From: Michael Eastham <Michael.Eastham@arun.gov.uk>
Sent: 09 December 2019 13:19
To: Planning.Responses <Planning.Responses@arun.gov.uk>
Subject: FW: Outline planning application A/122/19/OUT – Land off Arundel Road, Angmering - Revised Proposals

Subject: 2019-004 Angmering, Arundel Road - Revised Proposals

Re: **A/122/19/OUT - Land off Arundel Road, Angmering**

C	25.11.2019	SB	Client comments addressed
B	20.11.2019	SB	Client comments addressed
Rev	Date	By	Description
Clives Bents, High Street, Ashwell, Hertfordshire SG7 5NT t: 01462 748547 e: ashwell@csaenvironmental.co.uk w: csaenvironmental.co.uk			
Project	Land West of Arundel Road, Angmering		
Title	Development Framework Plan		
Client	Gladman Developments Ltd		
Scale	1:2500 @ A3	Drawn	JC
Date	May 2019	Checked	RR
Drawing No	CSA/3467/136	Rev	C

Site Boundary: **9.10ha**

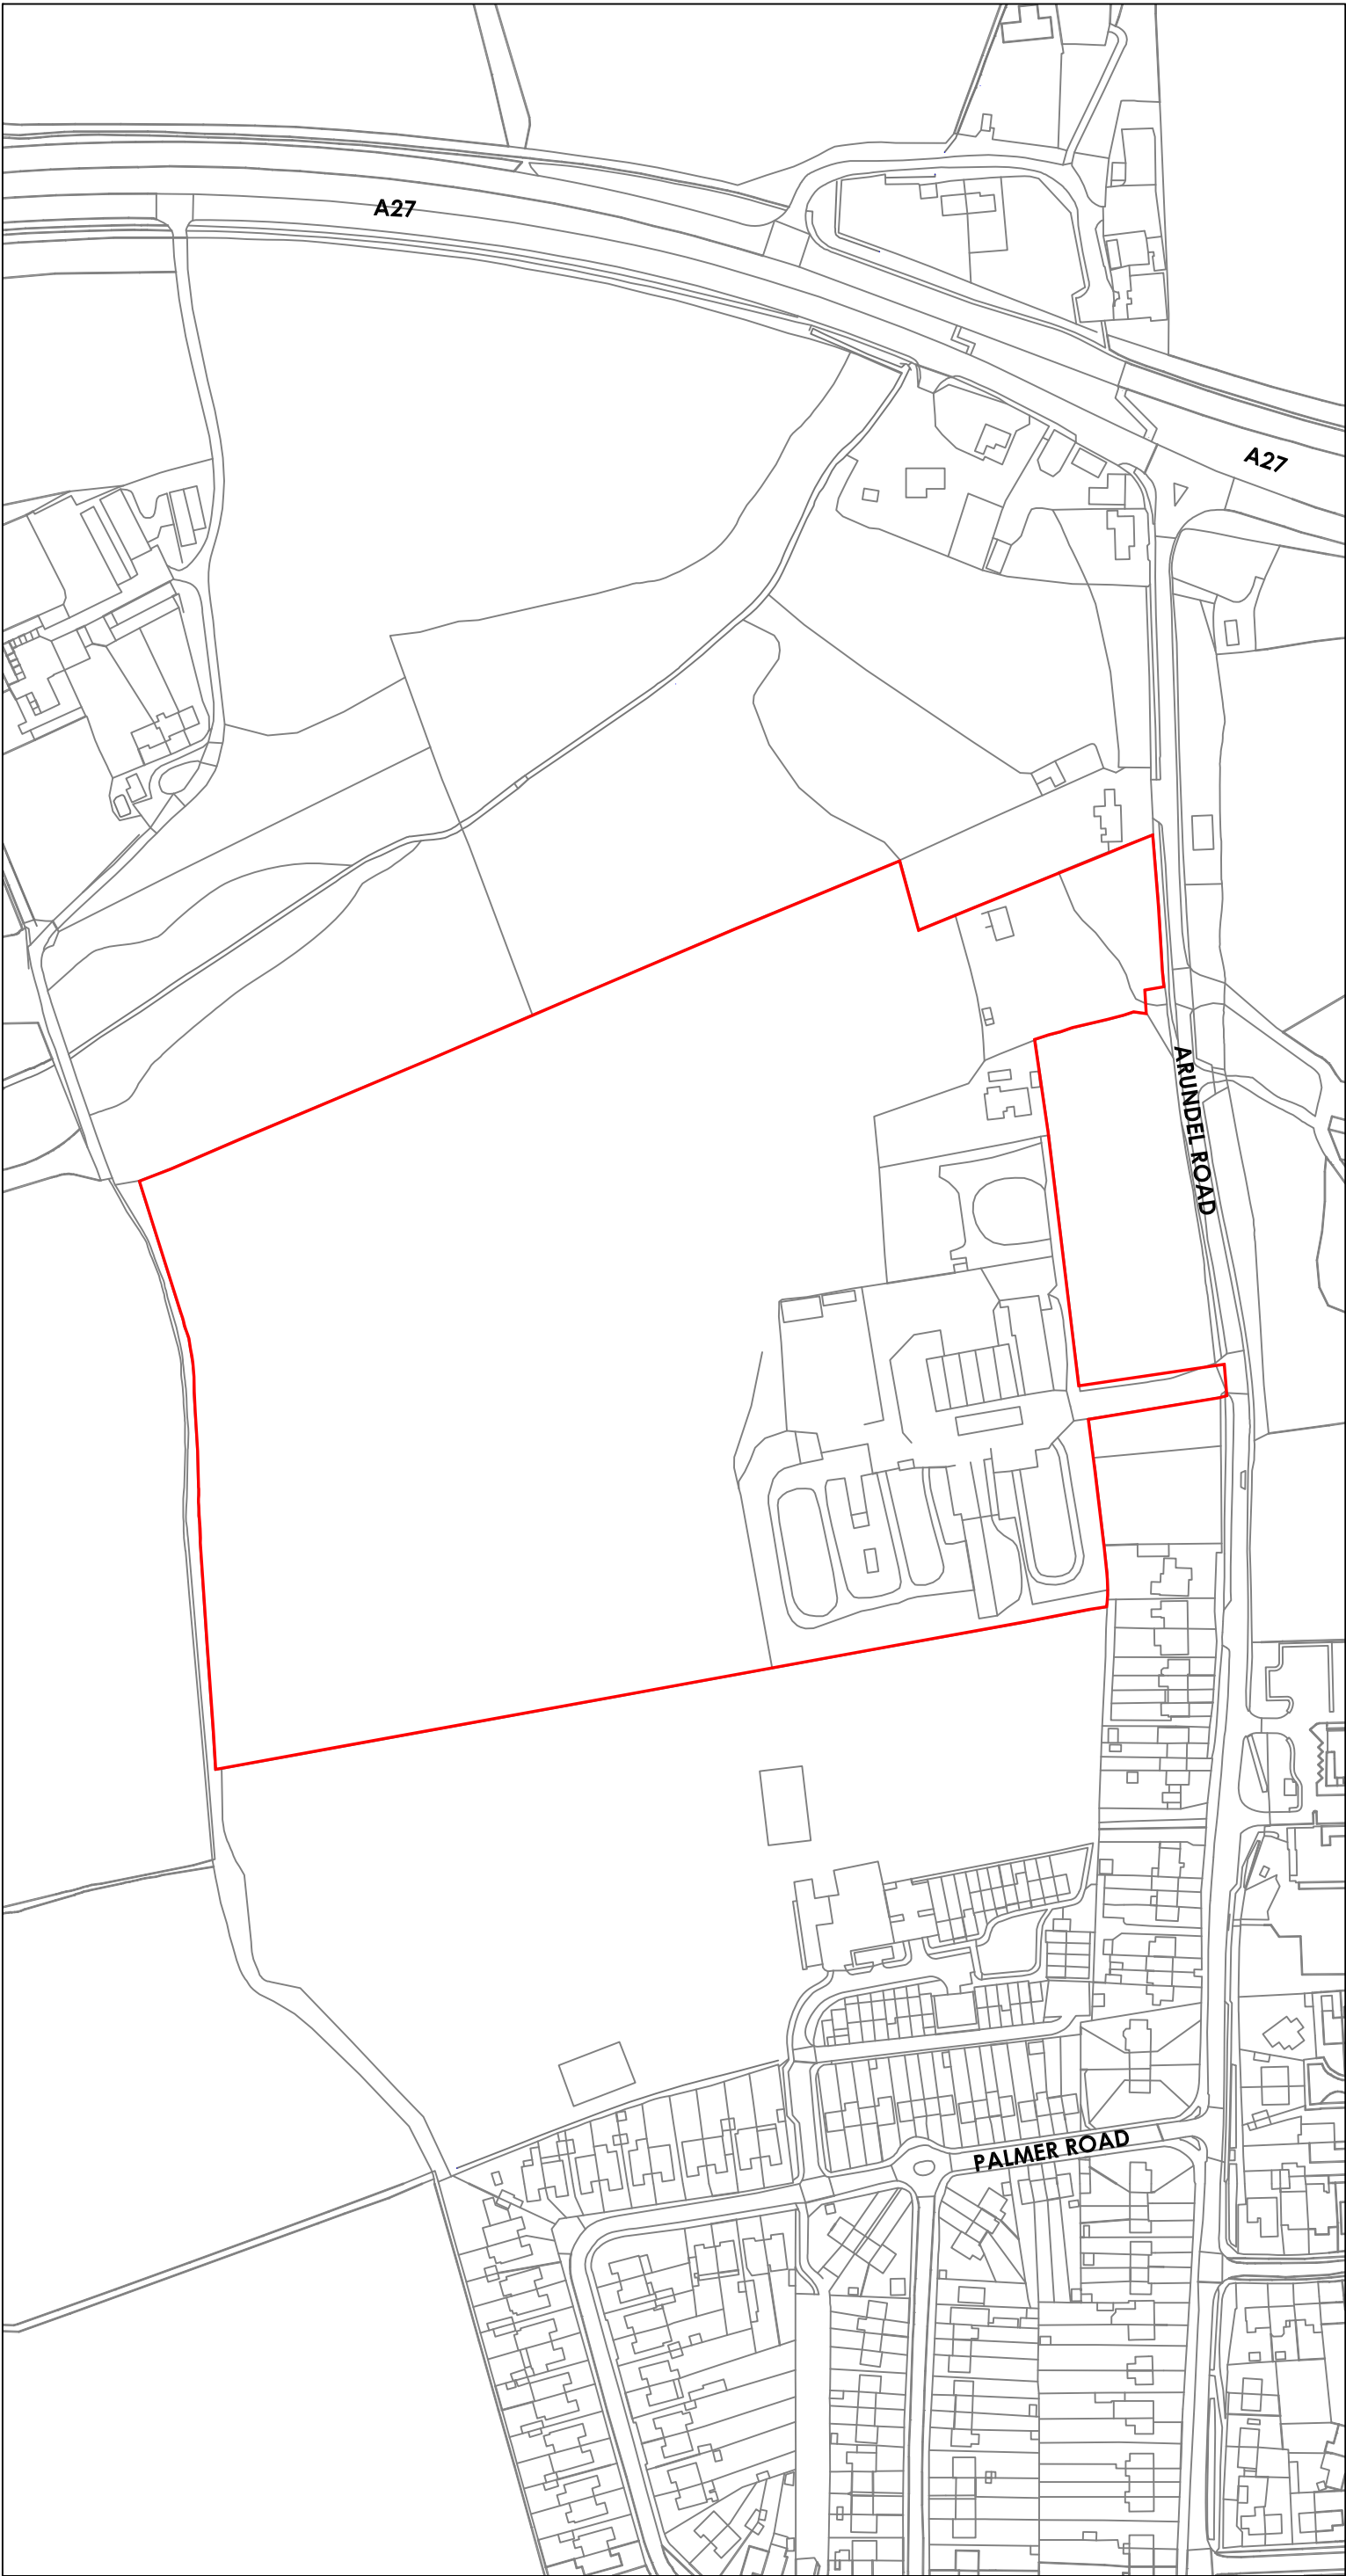
As discussed at our meeting on 22nd October and updates since, we have revised our proposals (see attached Development Framework Plan which supercedes the previously submitted one). We have included everything from our meeting and to summarise we:-

1. have squared-off and increased the amount of land available for the additional sports pitches;
2. have remodelled and relocated the POS. Calculations for the amount required by policy and the amount provided are shown below;

3. have allowed for the two trees covered by the new TPO to be retained unaffected by our proposals, and retained the links to wider PRow and pedestrian links– it should be noted that the final link would be required in land controlled by the District Council (from Palmer Road Recreation Ground);

4. have allowed for the provision of a 2.5m wide footpath and cycleway along the western boundary and linking to wider pedestrian links – it should be noted that the final link would be required in land controlled by the District Council (from Palmer Road Recreation Ground);
